**Relevant Representation of Suffolk
County Council in respect of the
proposals for the Sizewell C Nuclear
Power Station under section 56 of
the Planning Act 2008**

28 September 2020

DRAWING NO:
SZC-SZ0100-XX-000-DRW-100205

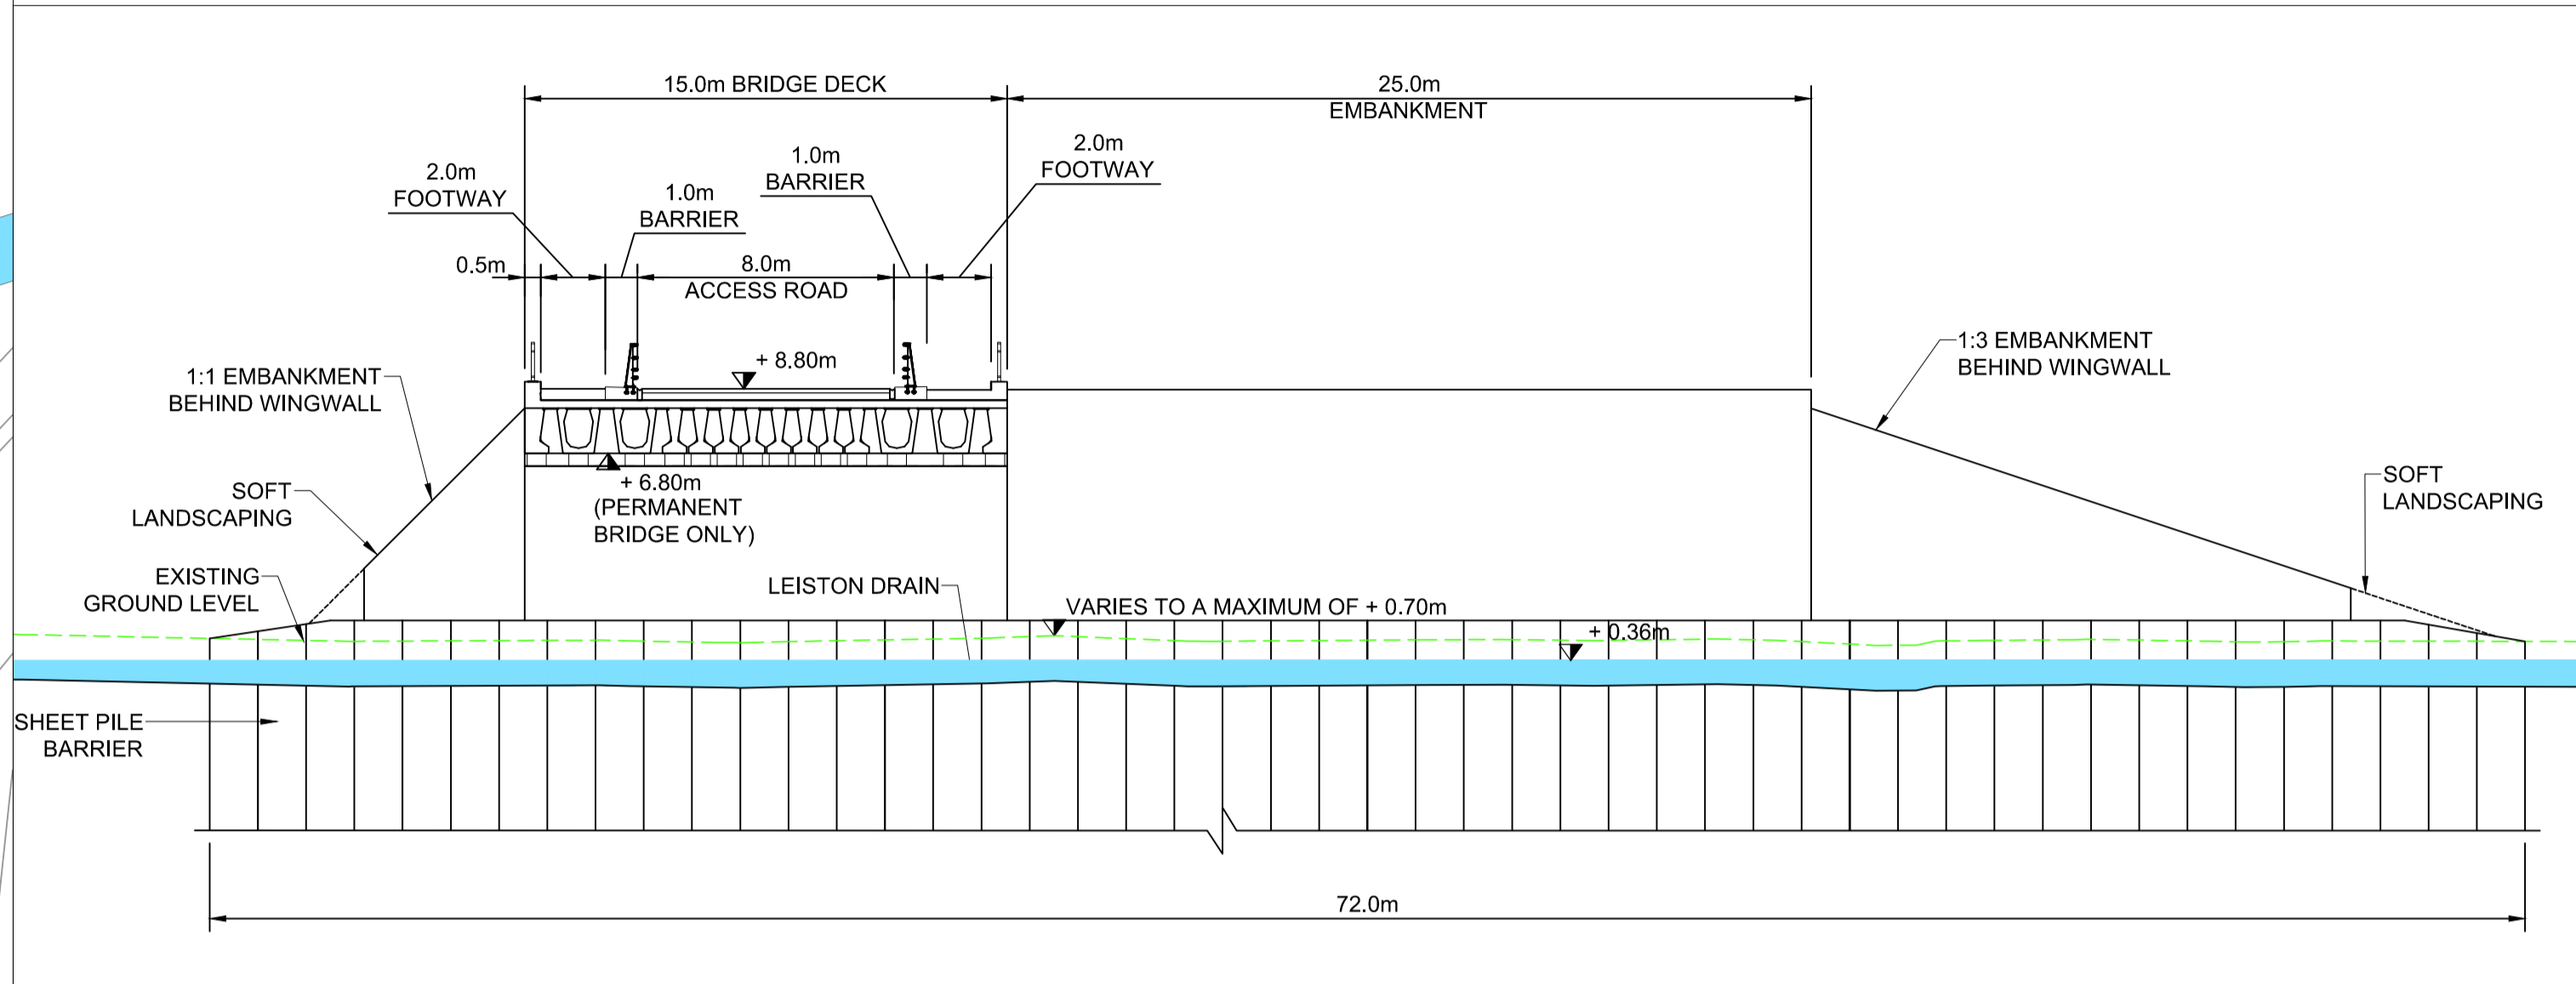
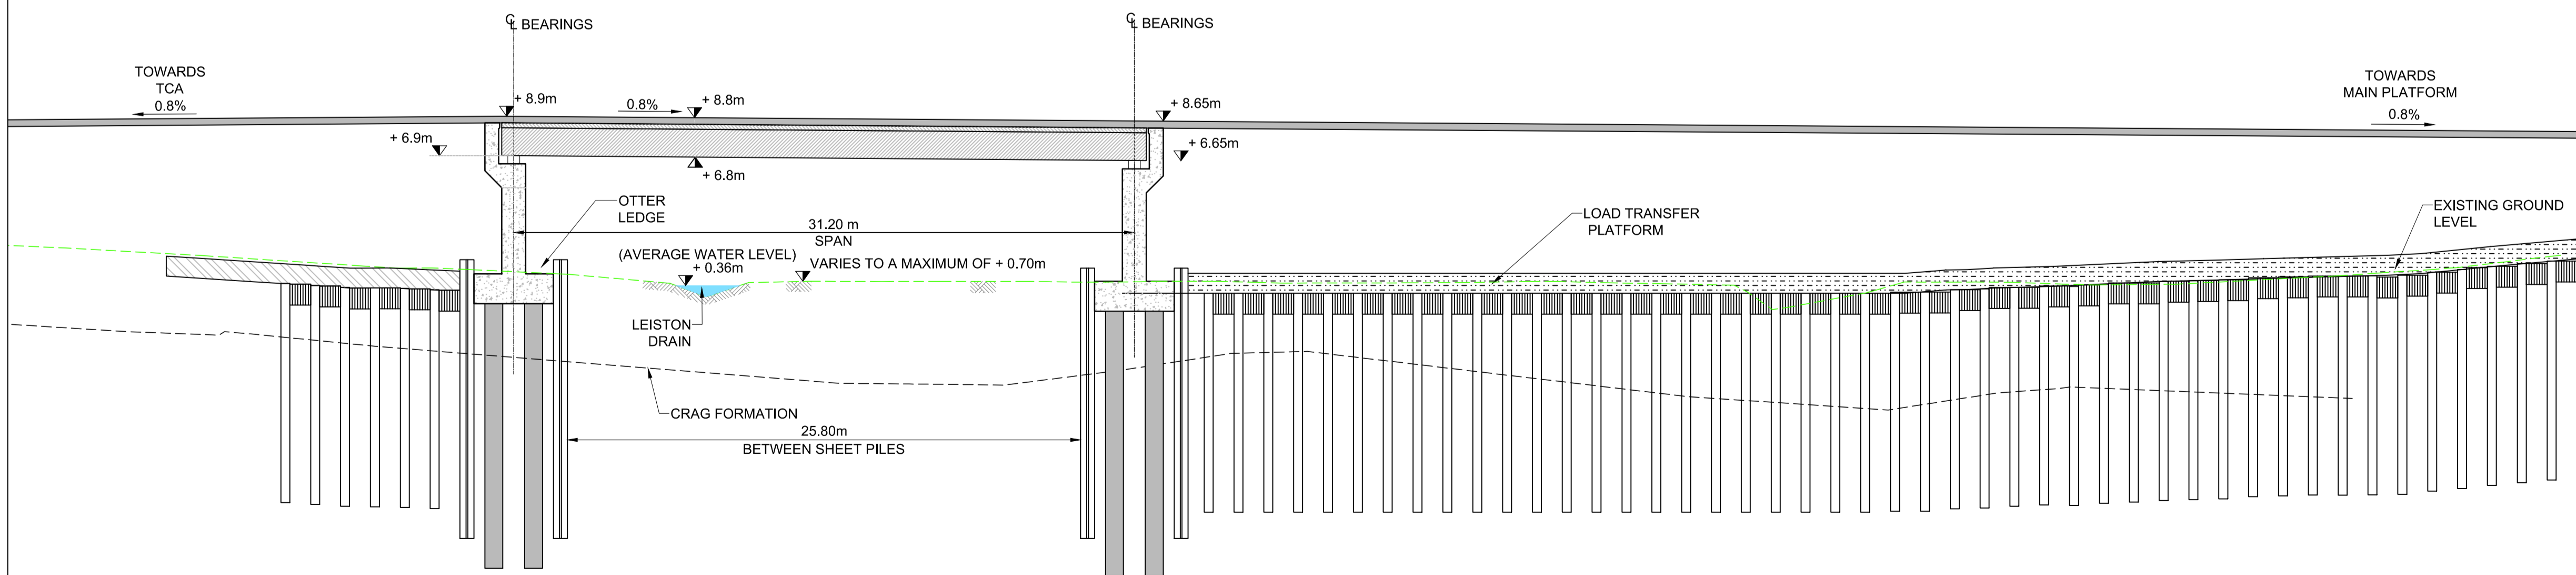
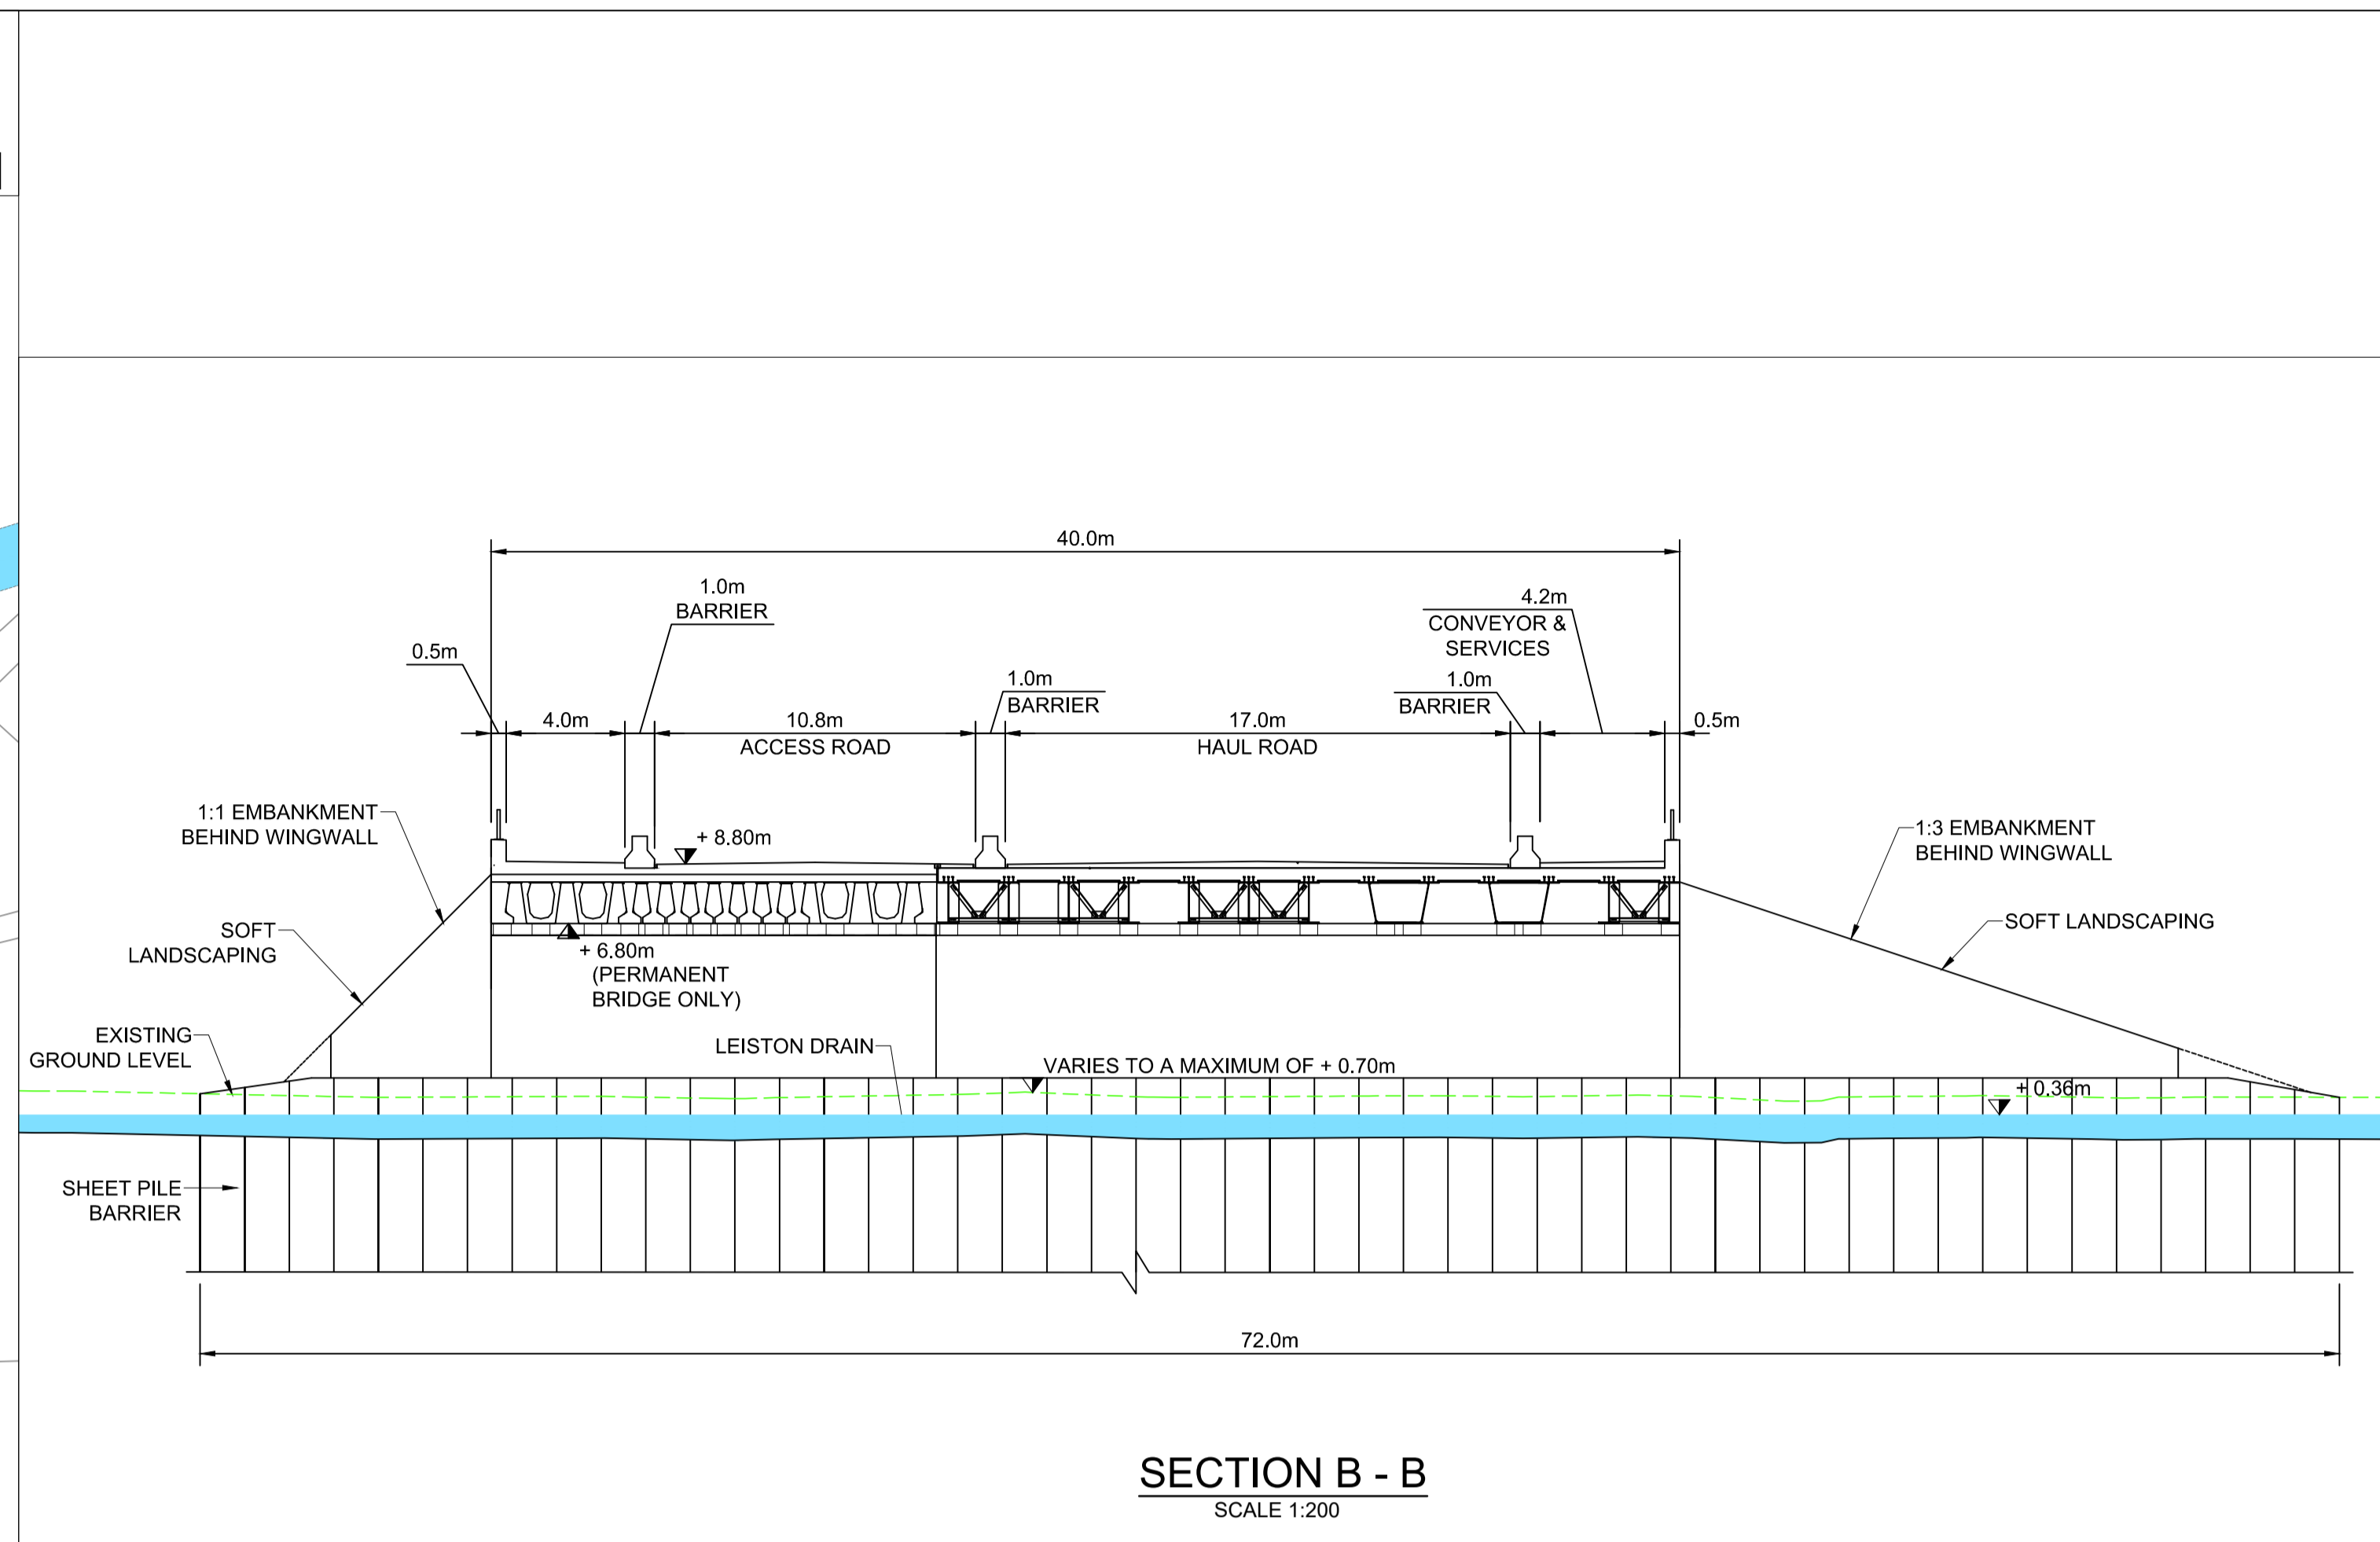
- vii) Replacing the proposed causeway to cross the Sizewell Marshes Site of Special Scientific Interest (SSSI) with a three-span bridge design, to reduce its ecological impact;
